**WELWYN HATFIELD BOROUGH COUNCIL  
EXECUTIVE DIRECTOR - PLANNING, PUBLIC PROTECTION AND GOVERNANCE**

**DELEGATED APPLICATION**

**Application No:** 6/2019/2591/HOUSE  
**Location:** 50 Plough Hill Cuffley Potters Bar EN6 4DS  
**Proposal:** Erection of a ground floor side/rear and first floor extension, including the construction of a rear dormer and installation of rooflights to facilitate the creation of habitable space within the loft and erection of front boundary wall and gates  
**Officer:** Ms Lucy Hale

**Recommendation:** Granted

PROPOSED ROOF PLAN

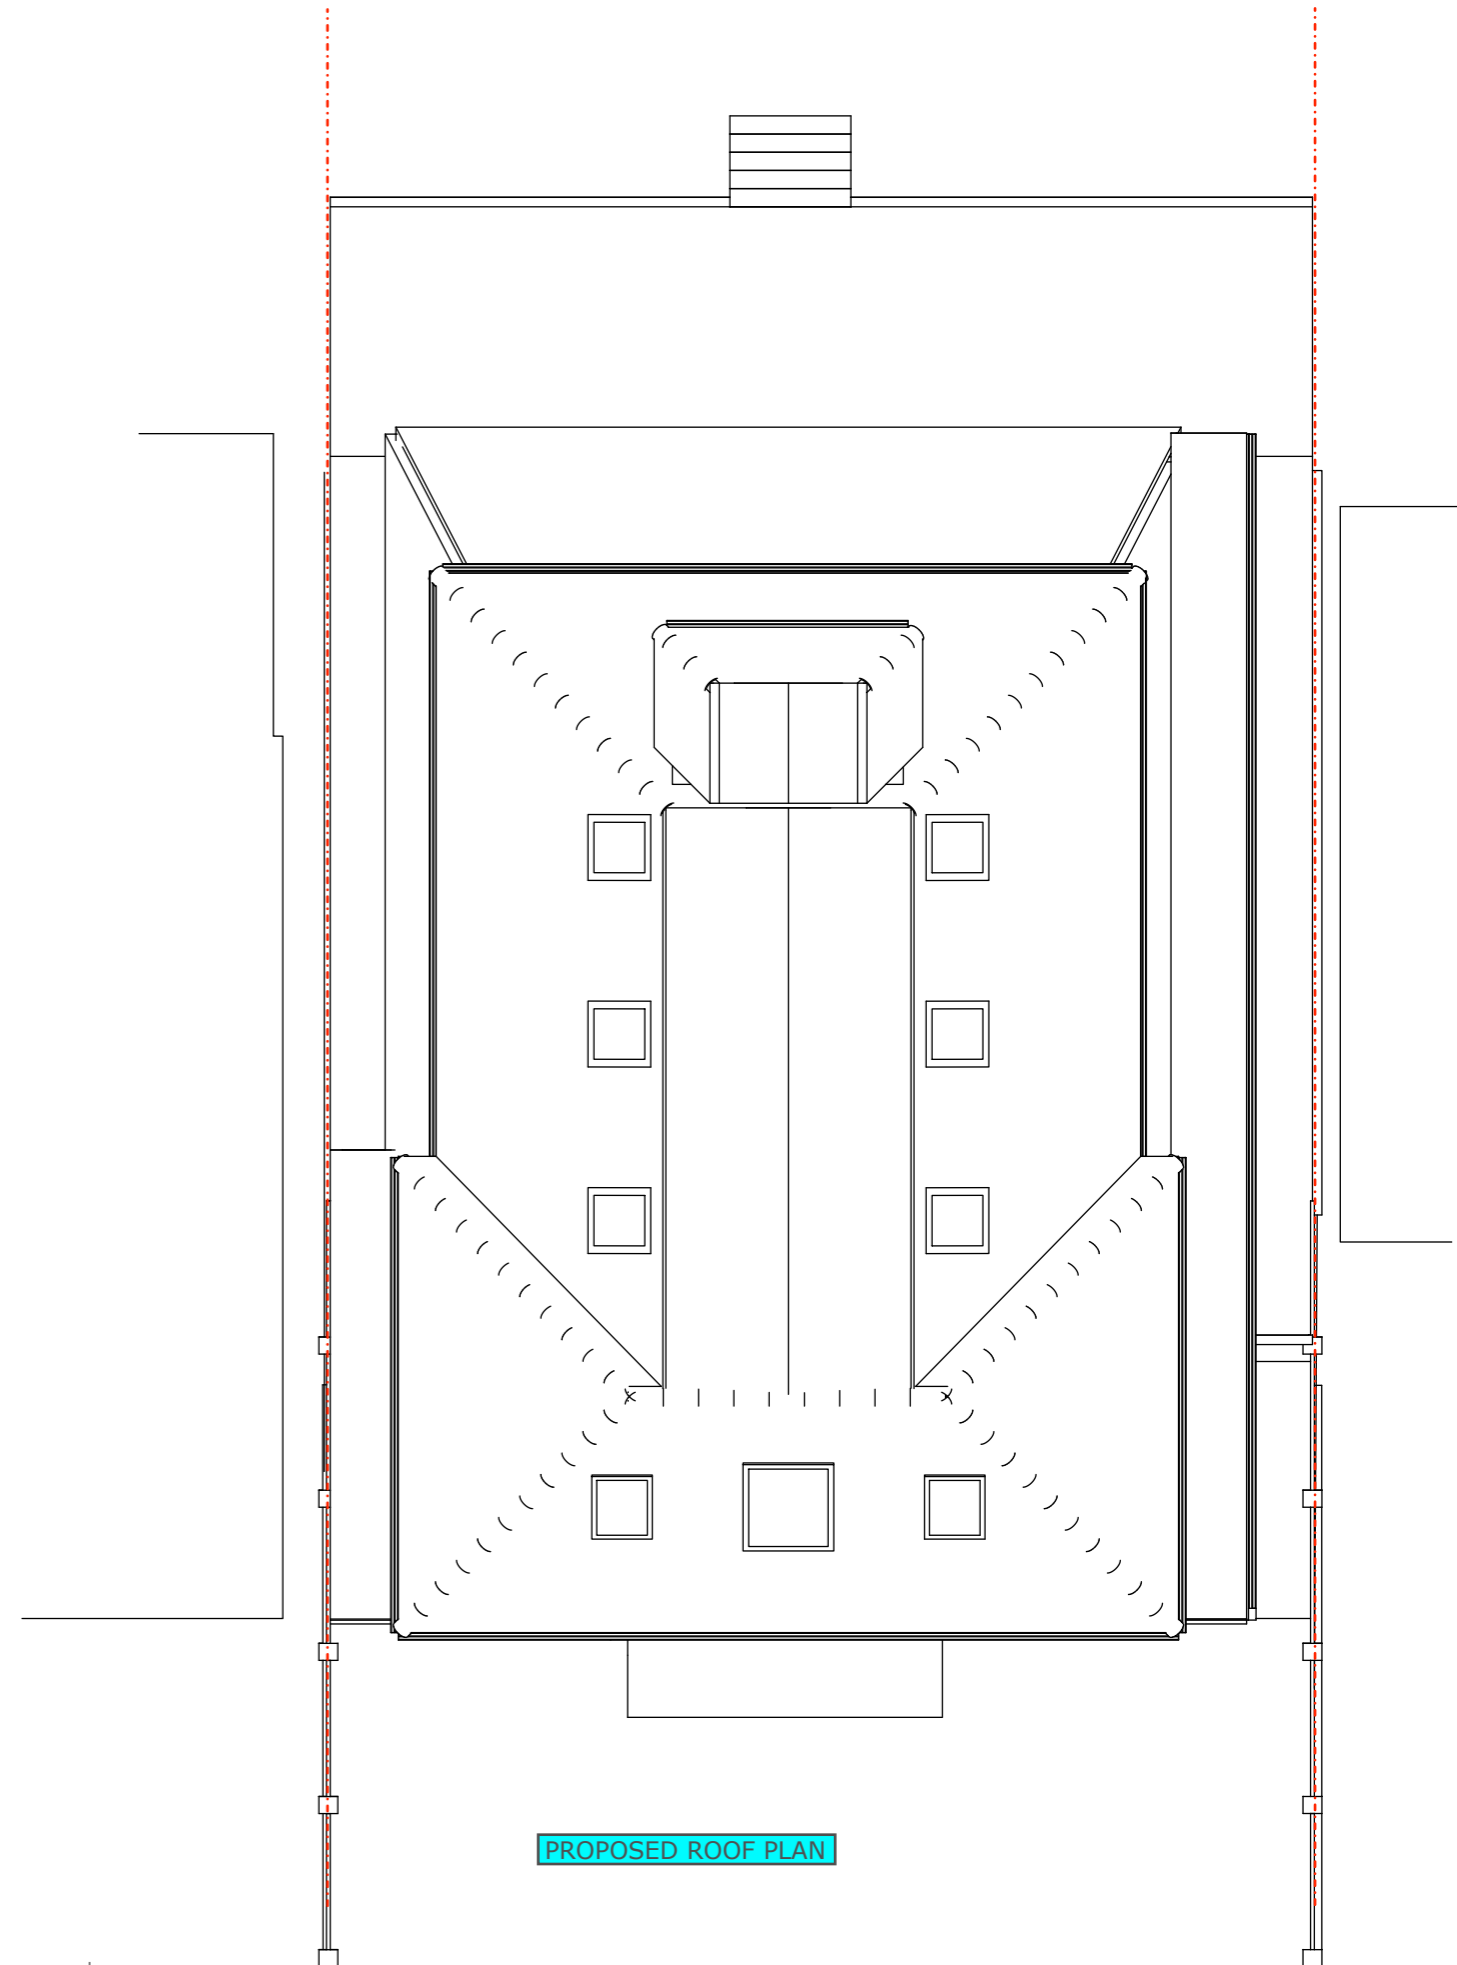
1. The roof tile of the approved extensions must match the roof tile of the existing dwelling in relation to colour and texture.

PROPOSED FRONT GATED WALL

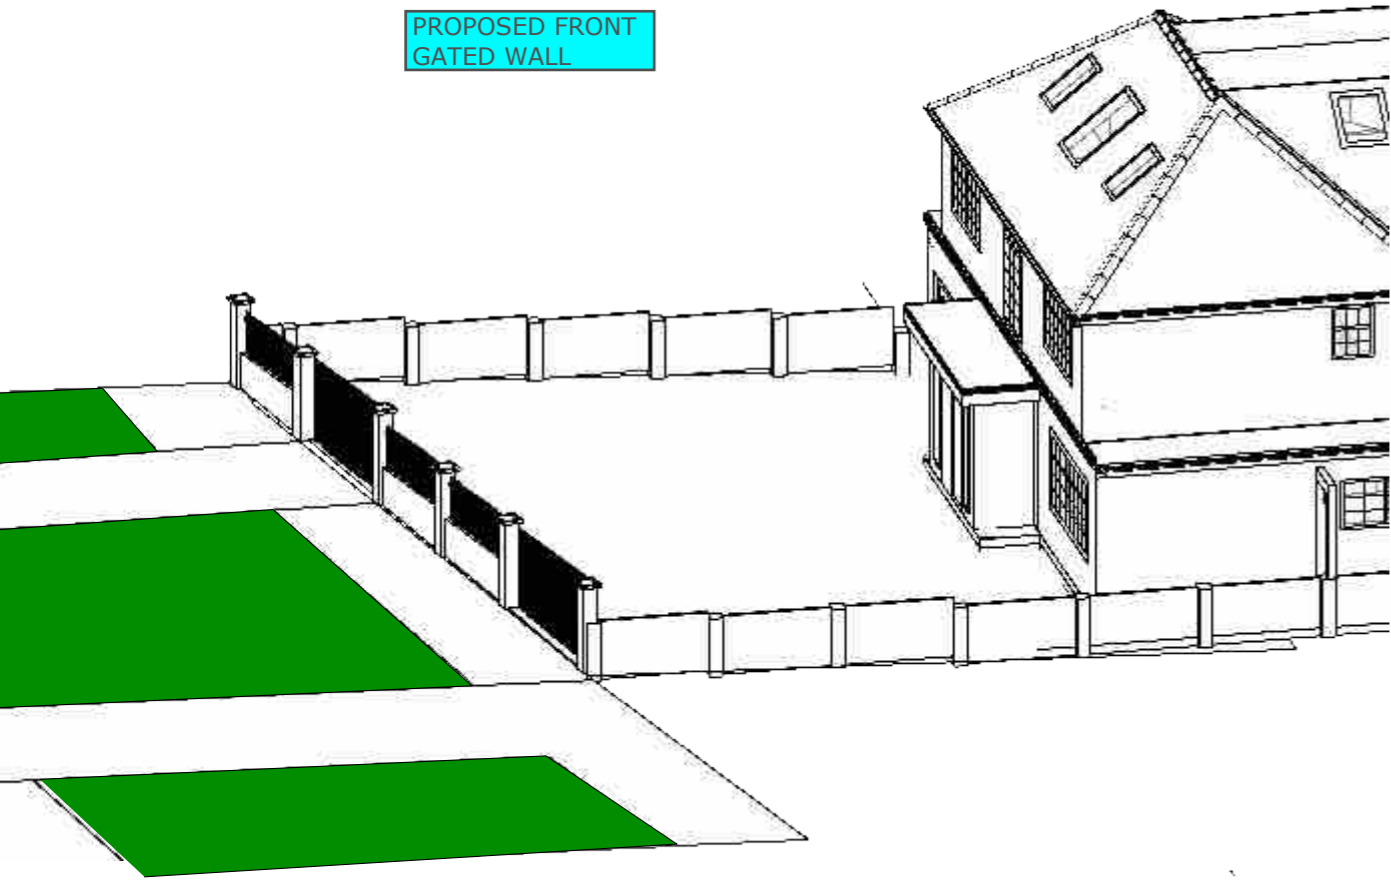
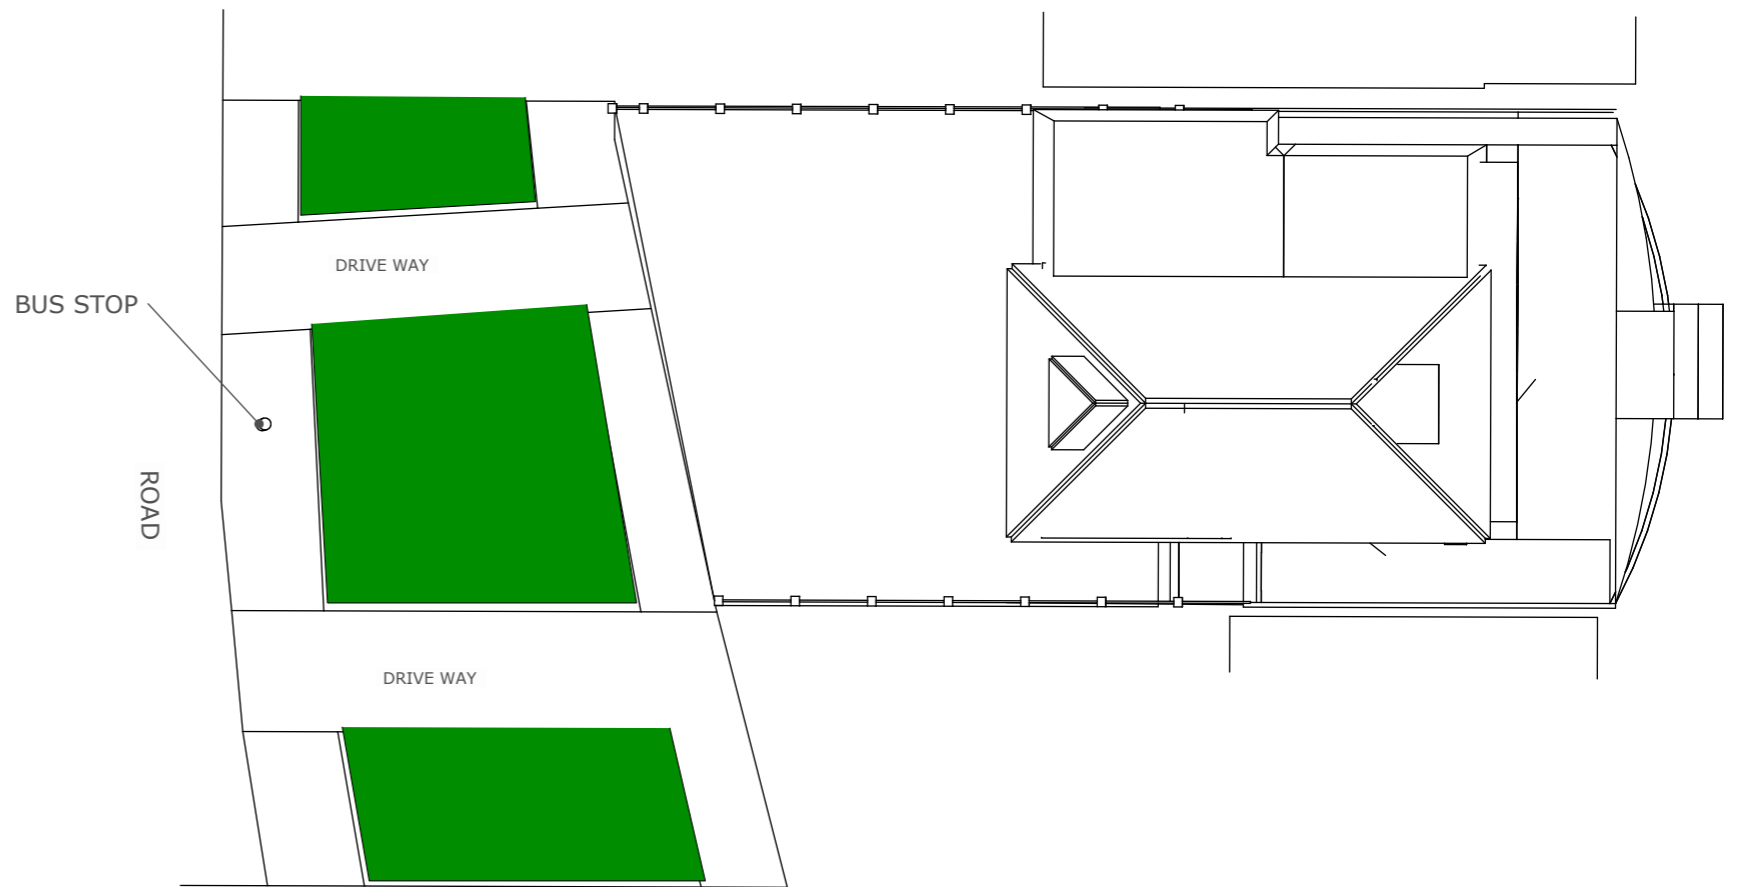
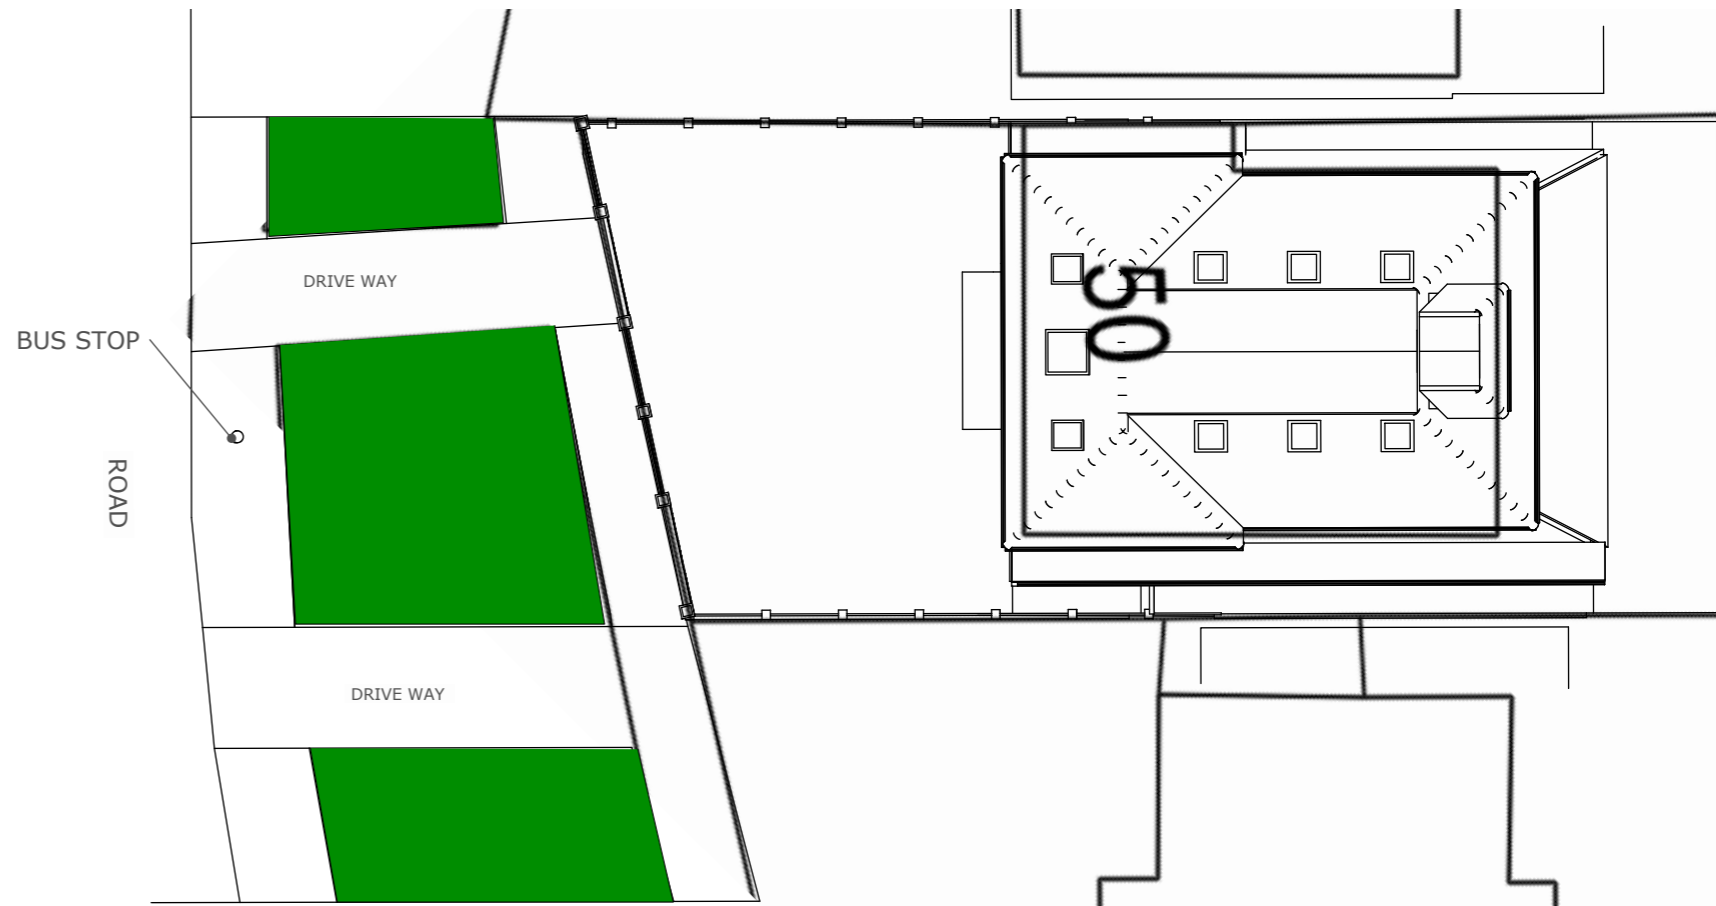
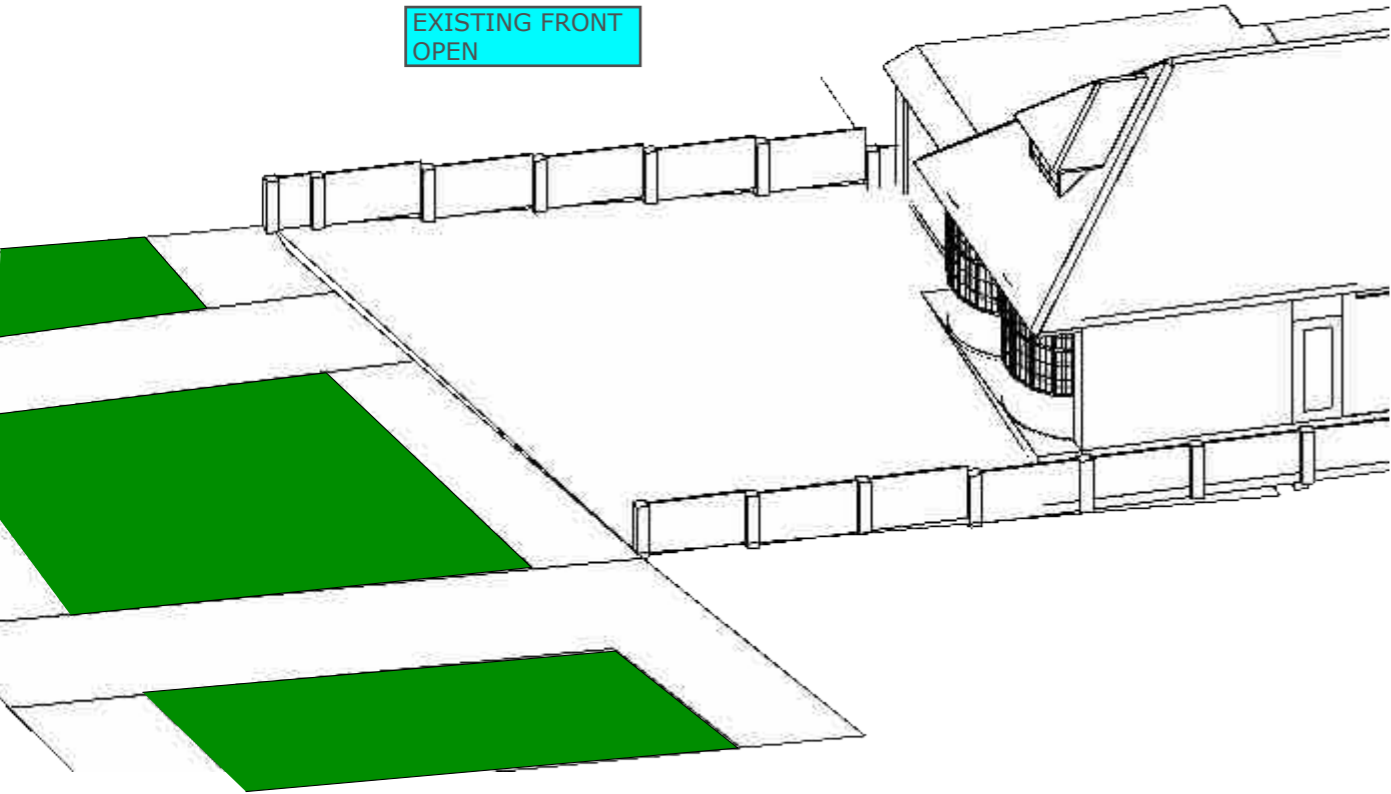
<u>Draft Local Plan Proposed Submission August 2016</u> SP1 Delivering Sustainable Development SP3 Settlement Strategy and Green Belt SP4 Transport and Travel SP9 Place Making and High Quality Design SADM2 Highway Network and Safety SADM11 Amenity and Layout SADM12 Parking, Servicing and Refuse			
<b>Main Issues</b>			
<b>Would the development reflect the character of the area?</b>			
<input checked="" type="checkbox"/> Yes <input type="checkbox"/> No <b>Comment</b> (if applicable):  The amendments to the approved scheme include alterations to the appearance of the extensions with a change of roof of the single storey front and side extensions to a flat roof design. Furthermore, the size and detailing of windows on the front and rear elevations have been amended. The changes to the proposal are considered to respect the appearance of the dwelling and character of the area. Furthermore, a crown roof section drawing has been submitted to confirm the flat roof to be no higher than the surrounding ridge tile. This satisfies the condition on the previous application.  A front boundary wall, piers, railings and gates are proposed. The front boundary wall would be painted white render to match the house and would be supported by six piers also of white render finish. The height of the piers would measure approximately 1.5/1.6m, the wall would measure approximately 0.6-0.77m in height with a black railing above, in total measuring 1.4m. The two black sliding gates which would measure approximately 1.45m in height.  The boundary treatment has been designed to reflect and respect the appearance of the property by virtue of the white render finish of the piers and wall and the black slender design of the railings and gates. In terms of scale and massing, as a result of its height and design, the proposal would not appear unduly dominant within the streetscene where a number of similar boundary features are witnessed nearby. Overall, the proposed boundary treatment is considered to maintain the character

PROPOSED LEFT ELEVATION

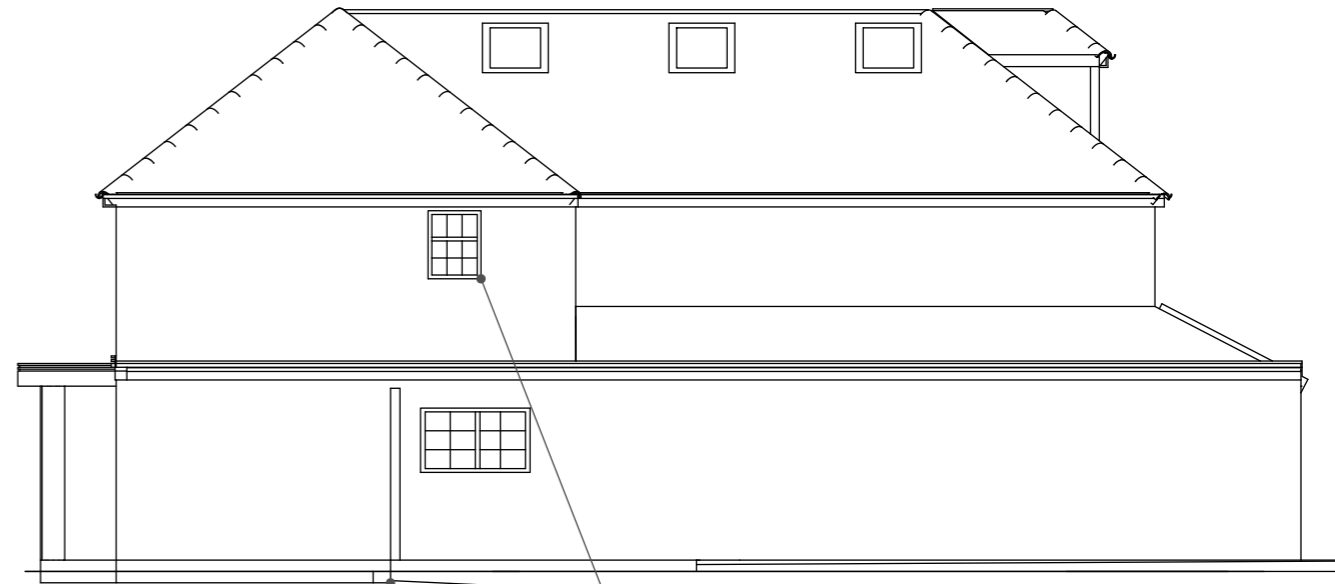
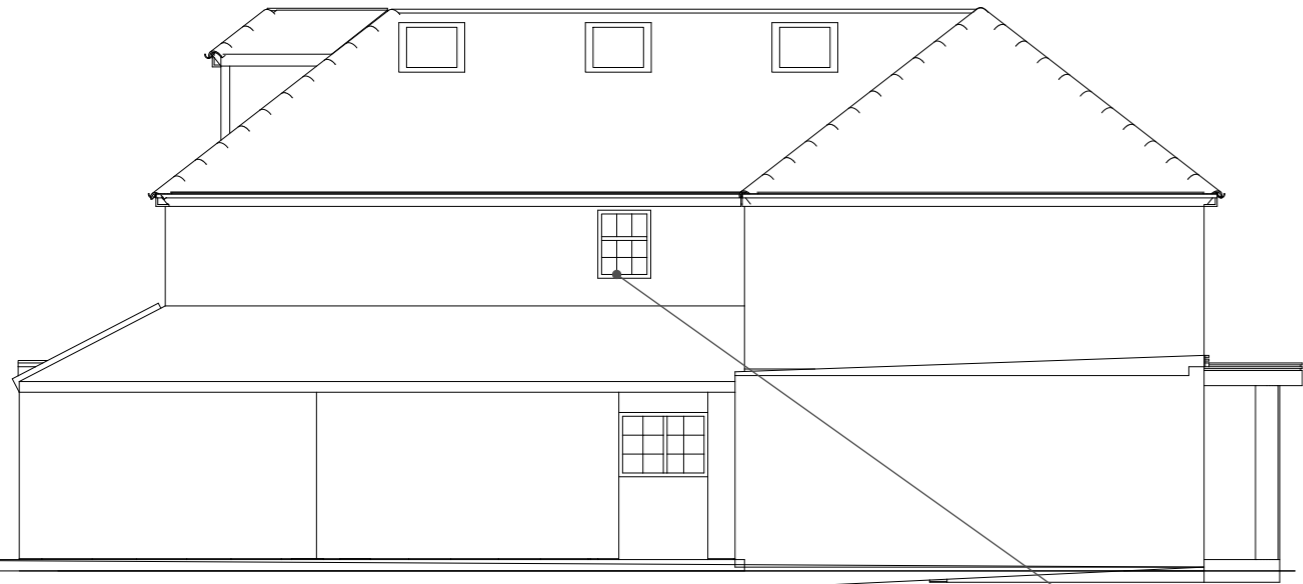
2. Any upper floor window located in a wall or roof slope forming a side elevation of the extension hereby approved must be obscure-glazed and non-opening unless the parts of the window which can be opened are more than 1.7 metres above the floor of the room in which the window is installed, and shall be retained in that form thereafter.
